File No: NTH09/01625/30

Your Ref: SSD8169 and MP09\_0028 MOD 3 (Concept Plan)

**State Significant Development Proposal (SSD\_8169) and  
Modification request MP 09\_0028 MOD 3 (Concept Plan) North Byron Parklands Cultural Events Site, Yelgun.**

LOCALITY PLAN
NOT TO SCALE

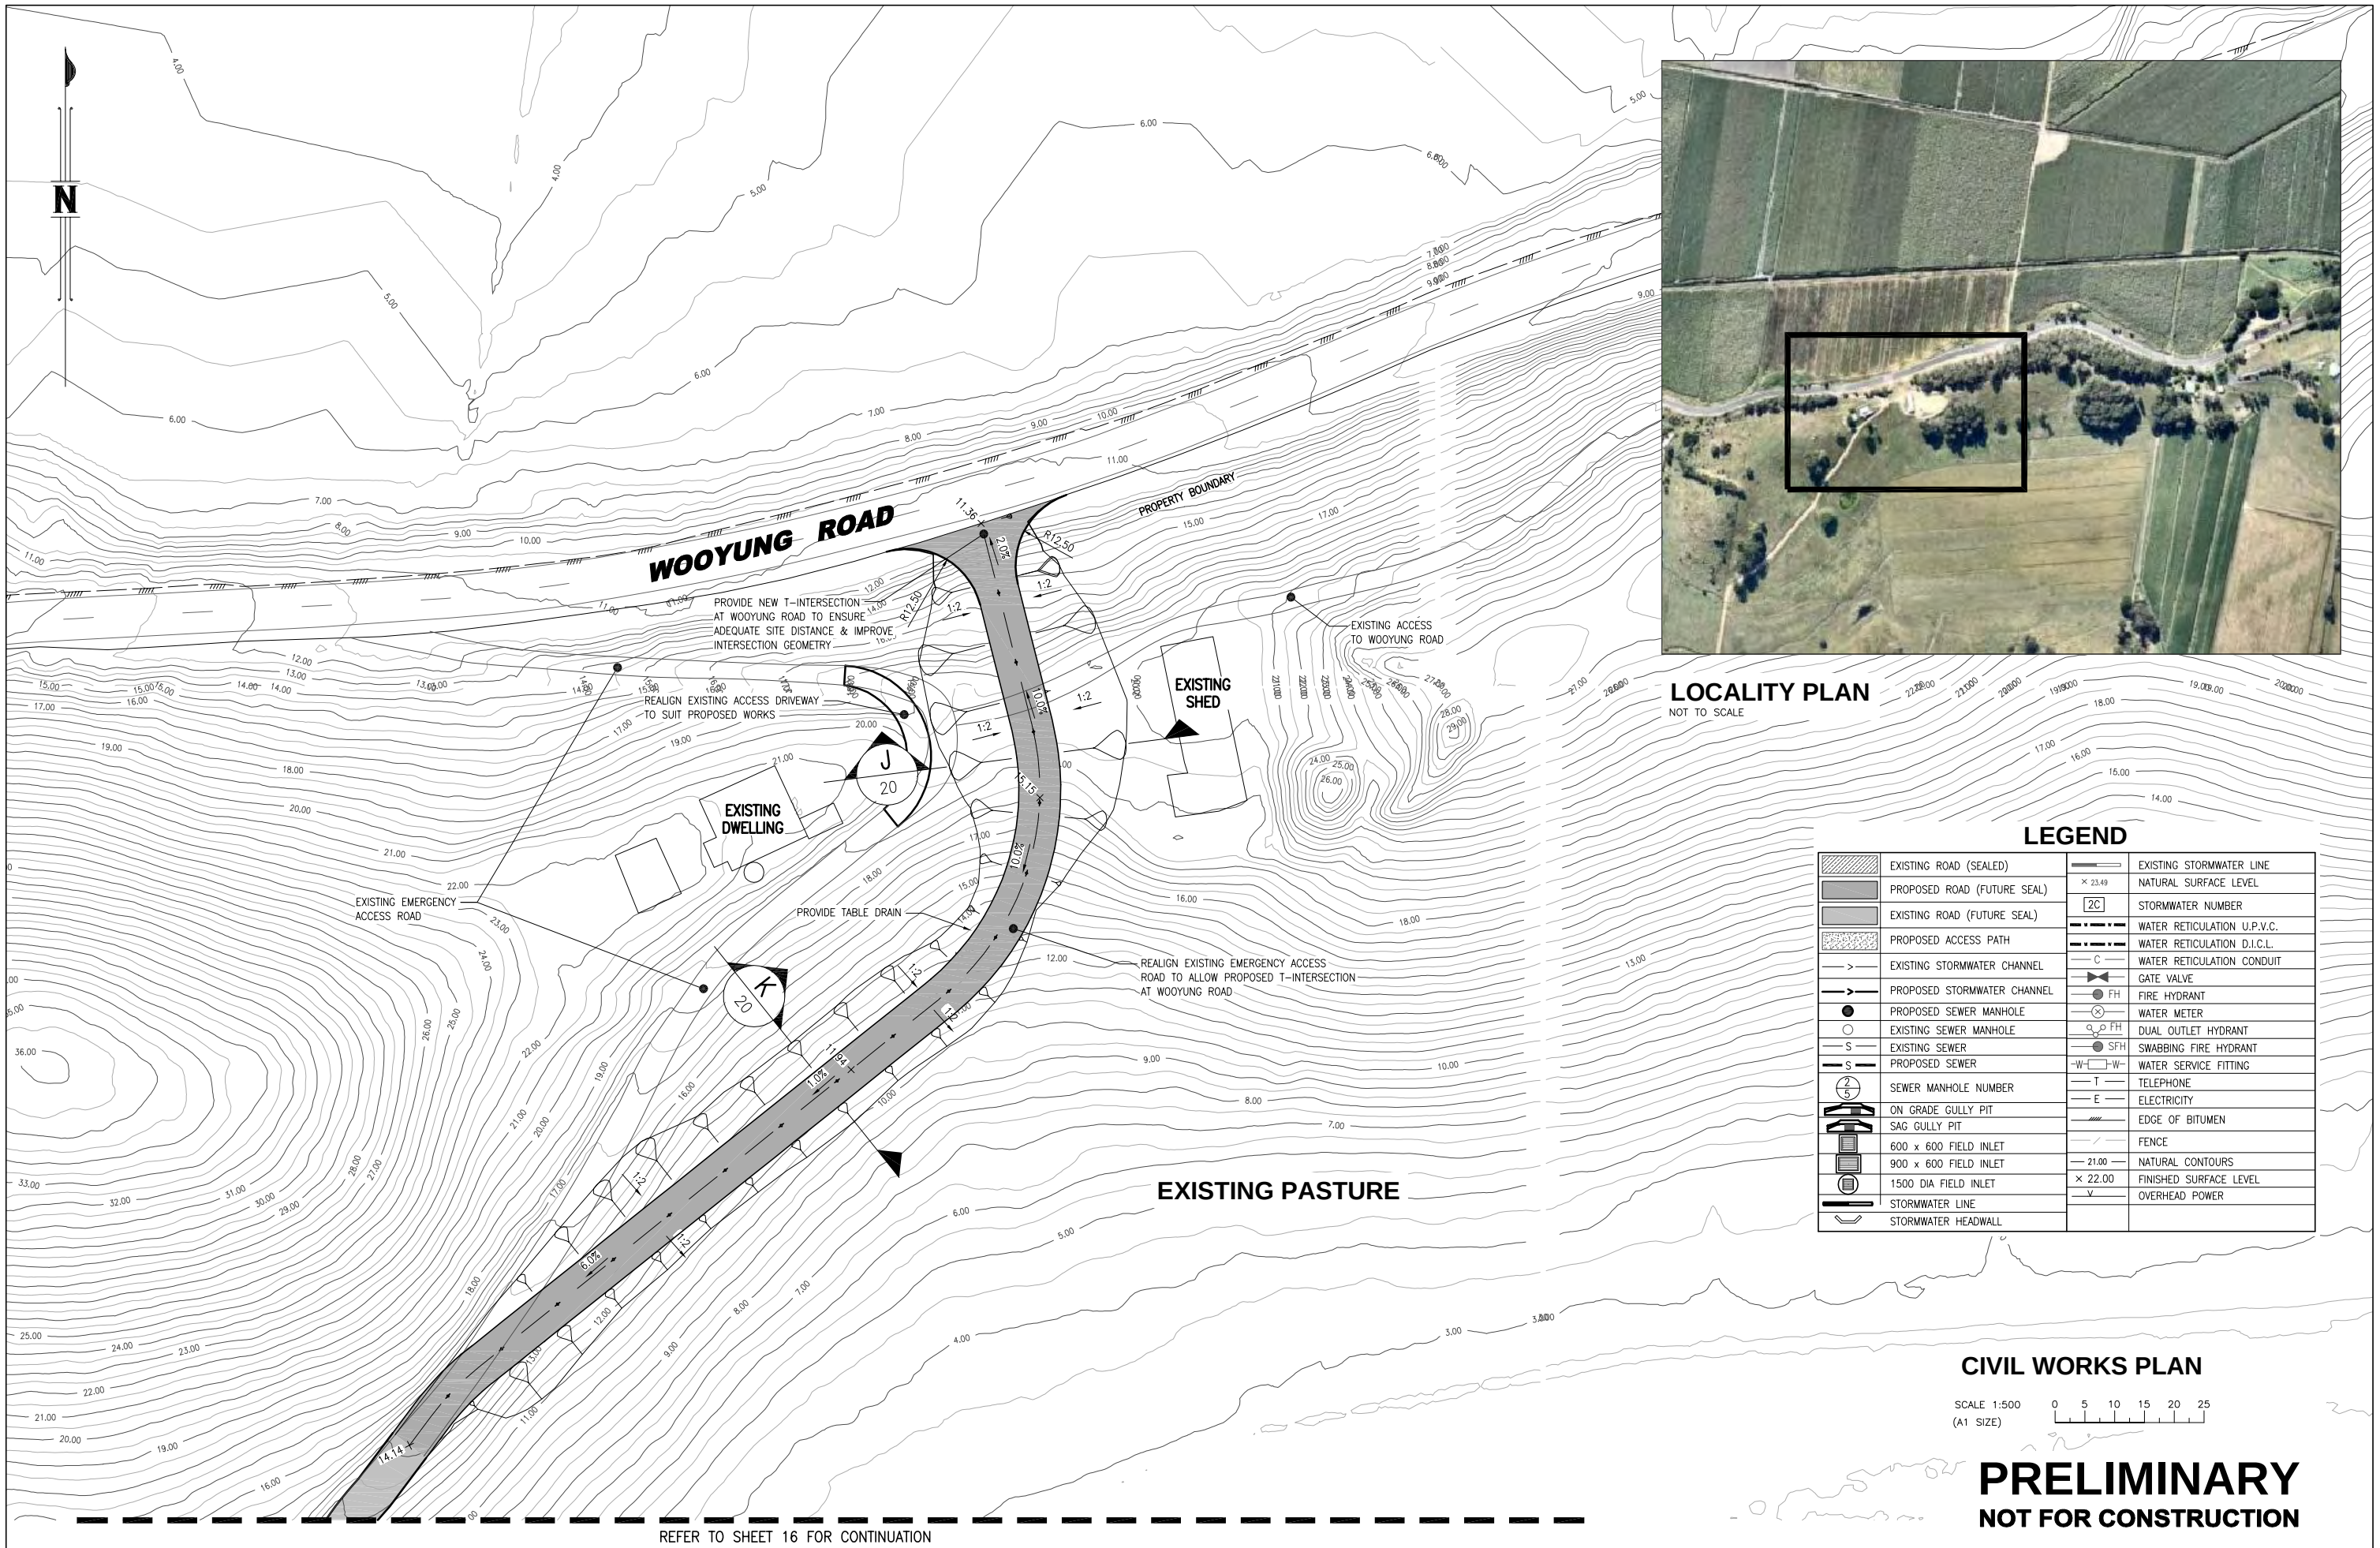
- Previously Gate E Wooyung Road has been used under the direction of NSW Police getting vehicles off the site during bump-out. This is proposed to become a camper and day patron entry and exit for parking only for vehicles arriving from the Tweed Coast Road. Clarification is required for the works proposed at Wooyung Road intersection and its use for parking.
